Application Reference Number:		2025/0150	
Application Type:		Full	
Proposal Description:		Installation of roller shutters, new windows and refurbishment of the existing windows	
Location:		17 Market Hill, Barnsley, S70 2PP	
Applicant:		Mr James Sixsmith	
Third-party representations:	None	Parish:	None
		Ward:	Central

This planning application has been submitted by Mr James Sixsmith and seeks full planning permission for the installation of roller shutters, new windows and refurbishment of the existing windows. The development is required to provide extra security to the premises.

Perforated Roller Shutter Detail

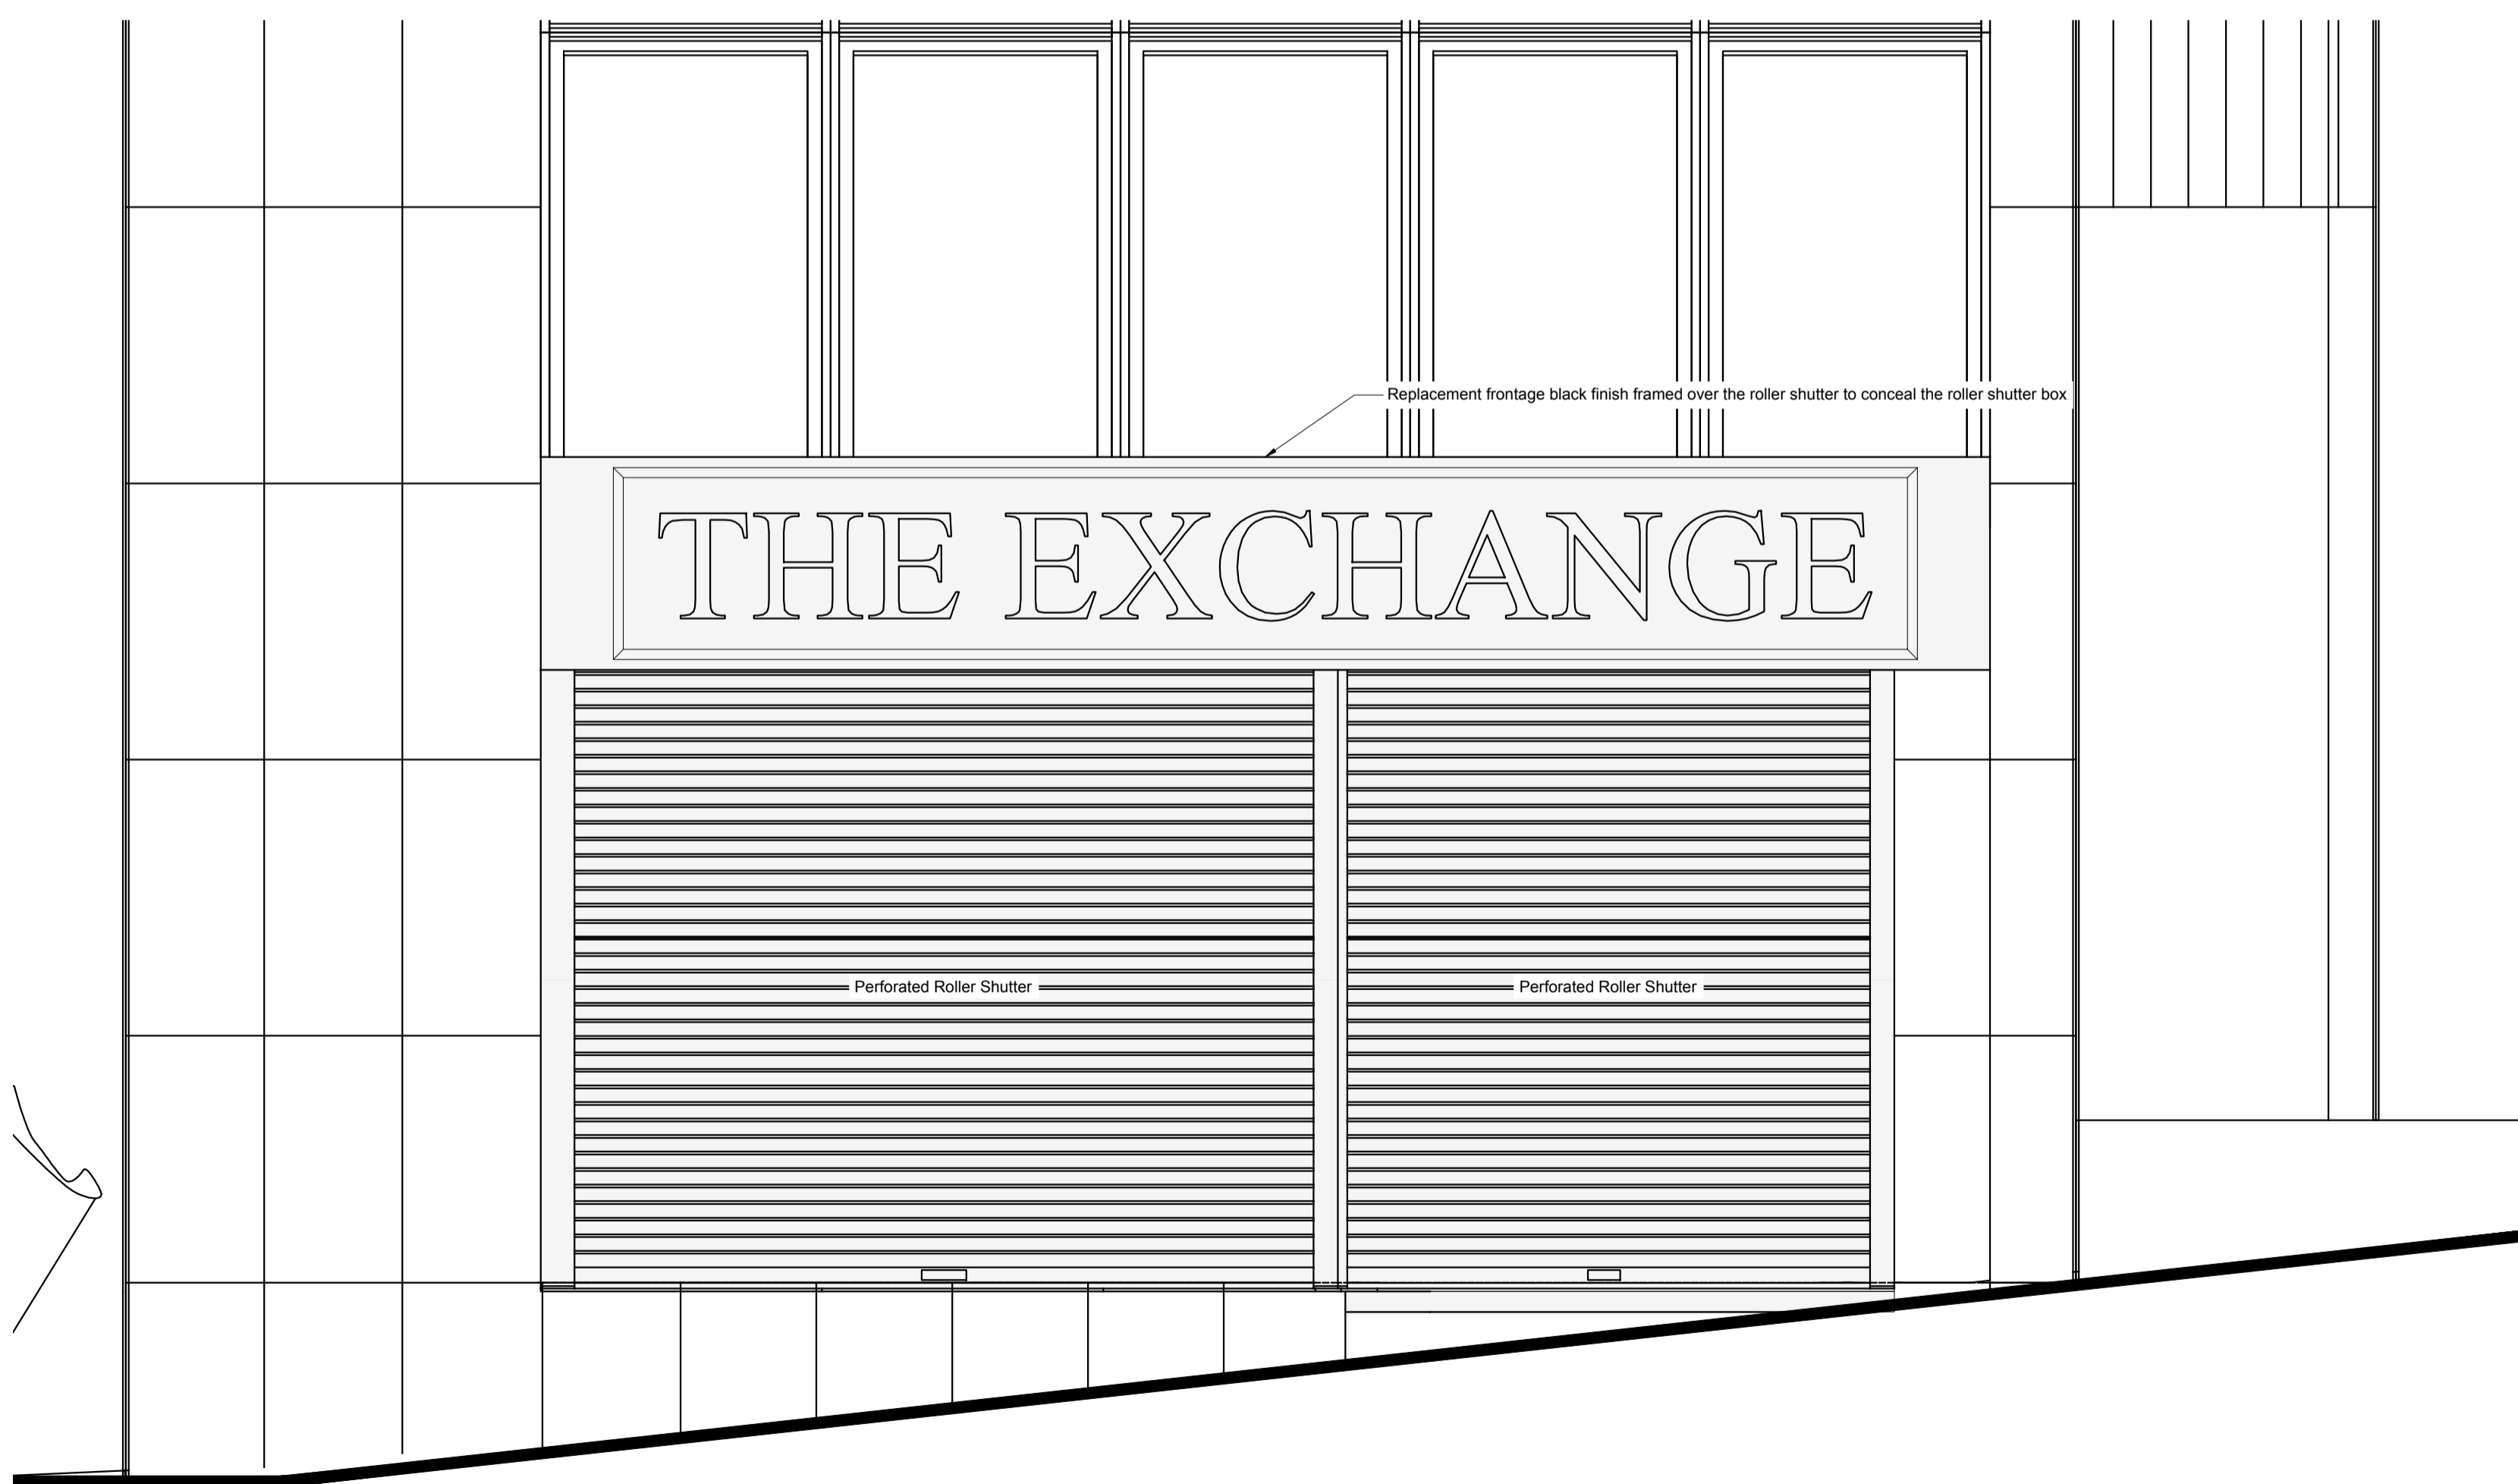
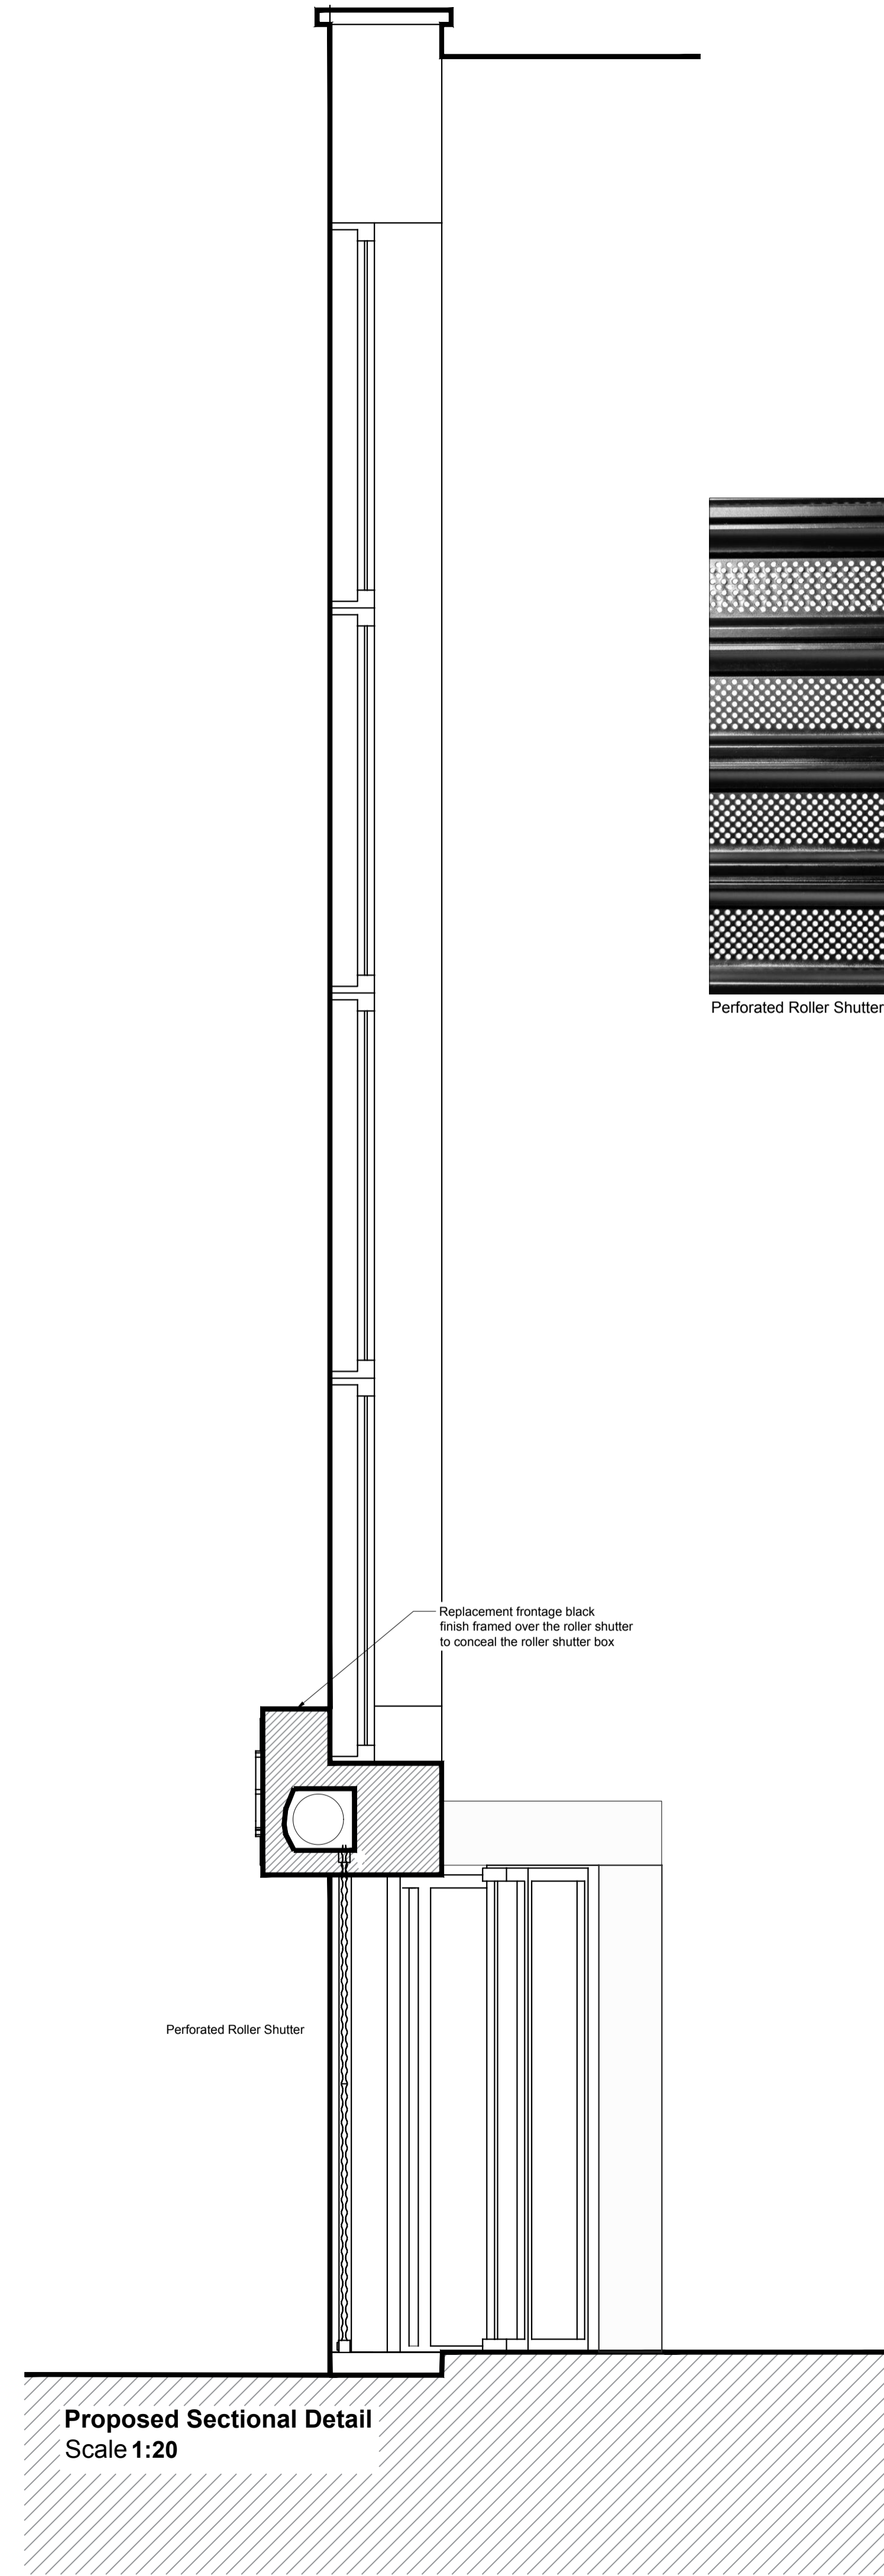
The initial proposal caused concerns over the impact over the extended roller shutter and shutter box and precedent this may set. Whilst 17 Market Hill has little heritage value, the setting is still sensitive. The visual impact of the shutter box on the fascia as well as the extended shutter itself could have been significant and caused visual harm.

To mitigate this there has been an integration of the shutter into the fascia/signage area, so that when retracted it is less visible. This also requires a separate advertisement consent application separately. The shutter is to be decorated black to harmonise with the building frontage and the windows above. The amendments to the shutter therefore reduce the impact it has on the setting of the adjacent listed buildings and the conservation area therefore given the high quality of design and materials it is deemed that the proposal will not harm the adjacent listed buildings nor the conservation area. This weighs significantly in favour of the proposal.

- Amendment to roller shutter to reduce overhang and remove shutter box
